THE COTTAGES AT MESA RIDGE PUD/ PRELIMINARY PLAN

PUD/ PRELIMINARY PLAN
PRELIMINARY GRADING PLAN

SHEET GR 7

Grading Plan_V2.pdf Markup Summary 2-14-2022

PUD/ PRELIMINARY PLAN
PRELIMINARY GRADING PLAN

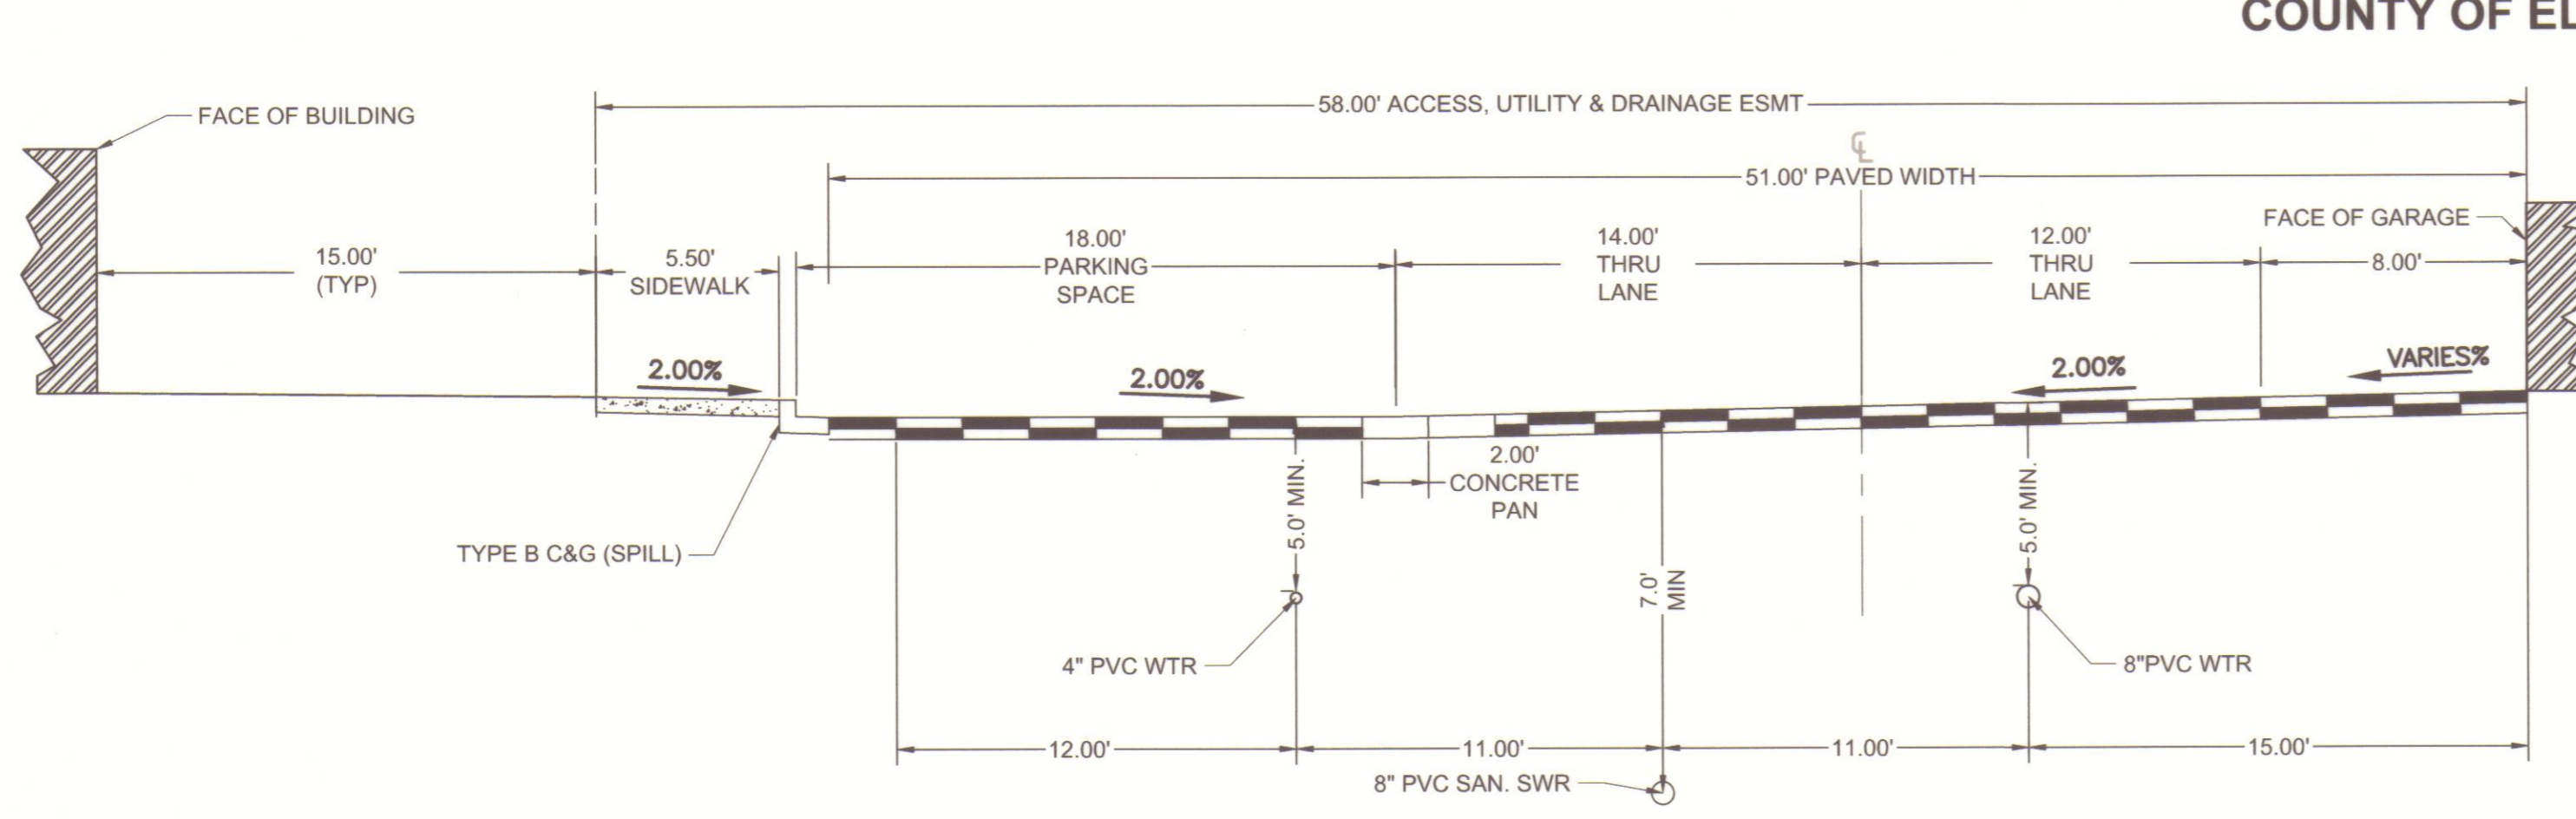
There is a +/- 5' difference where the proposed contours tie to the existing contours. Staff understands from the response you provided for the drainage report that the survey could not be completed as access was not granted by the existing residents of the lots along the property boundary.

Please provide a note stating that and that the existing contours shown on the existing lots are only to show the drainage patterns at this location (please use your own words for this note).

Please provide additional contour labels throughout the plan as done in the previous submittal.
